Application for a non-material amendment following a grant of planning permission.

Erection of 4 No dwellings & associated works. This application is a Departure from the Development Plan.

Reference number:	BN/39/20/PL
Date of decision	04/09/2020

04 | Side (South) Elevation  
Scale 1:50 @ A1

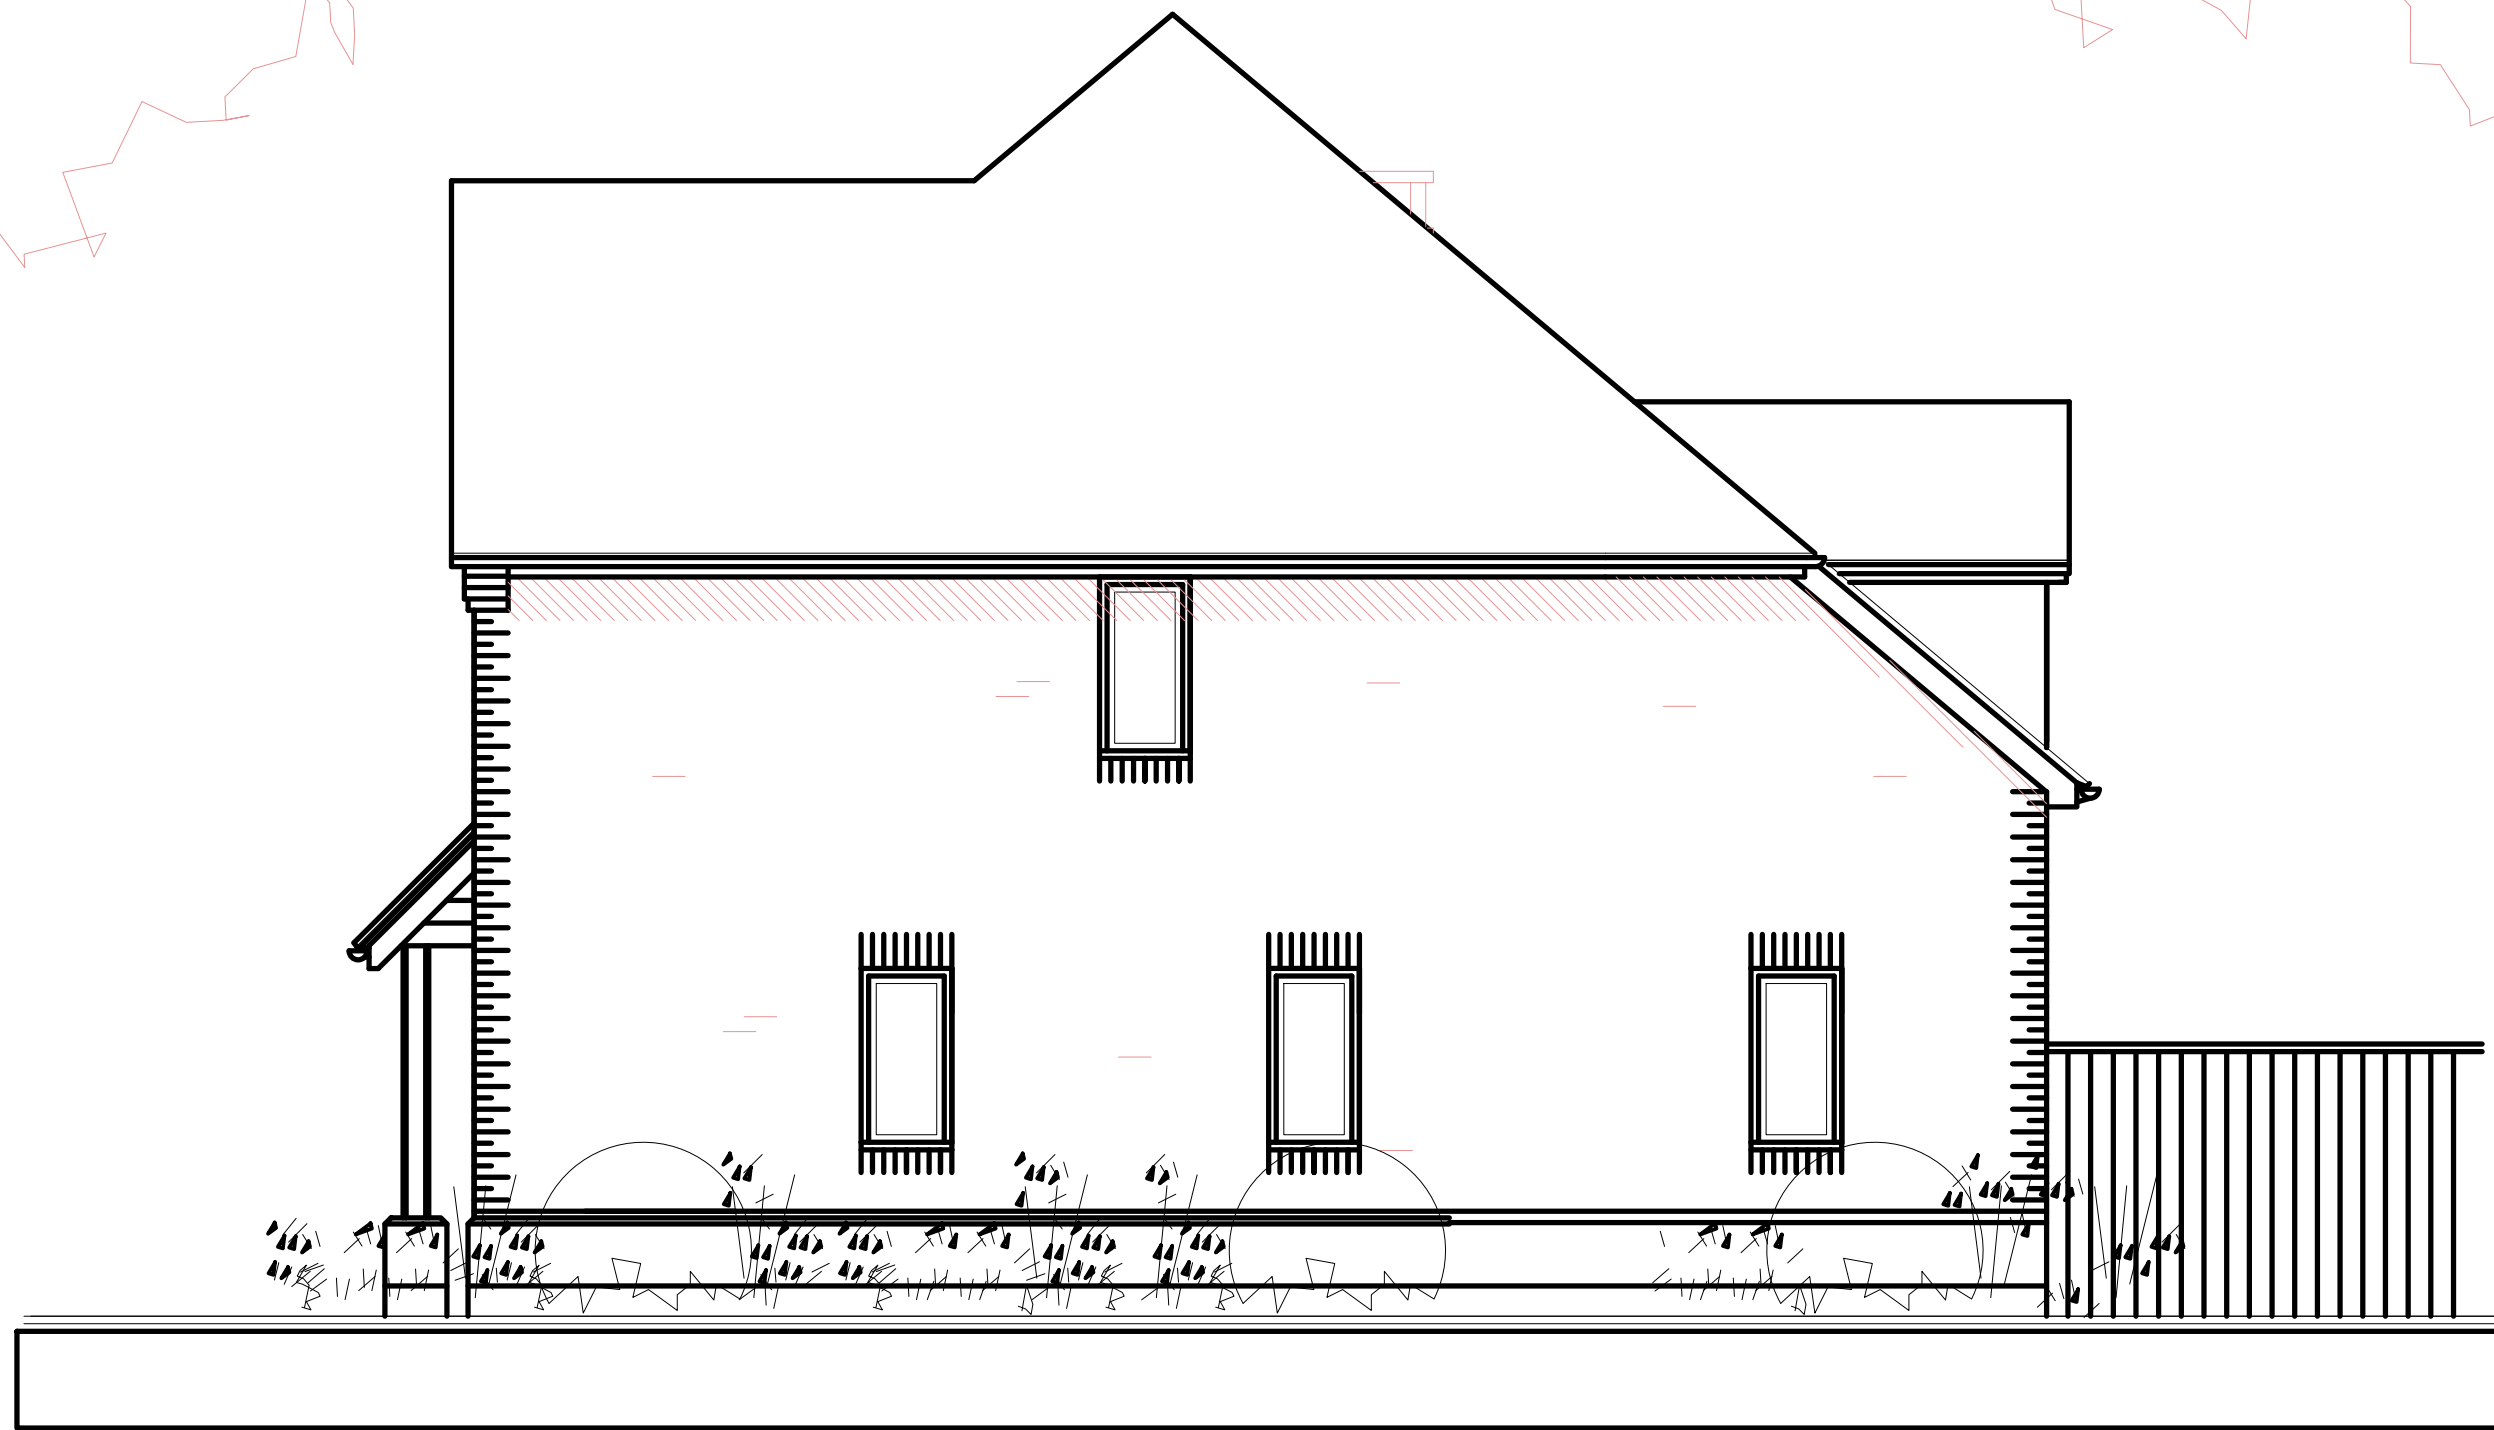
1. Road surface material to inner site drive changed from block paving to gravel matching the existing access track.
2. Plot 1 (internal amendments not impacting externally).
3. Plot 4 (internal amendments not impacting externally).
4. Plot 1 chimney handed to other side of dwelling.
5. Plot 1 stepped access introduced.
6. Plot 4 bulk of dwelling handed with chimney moved to external wall.
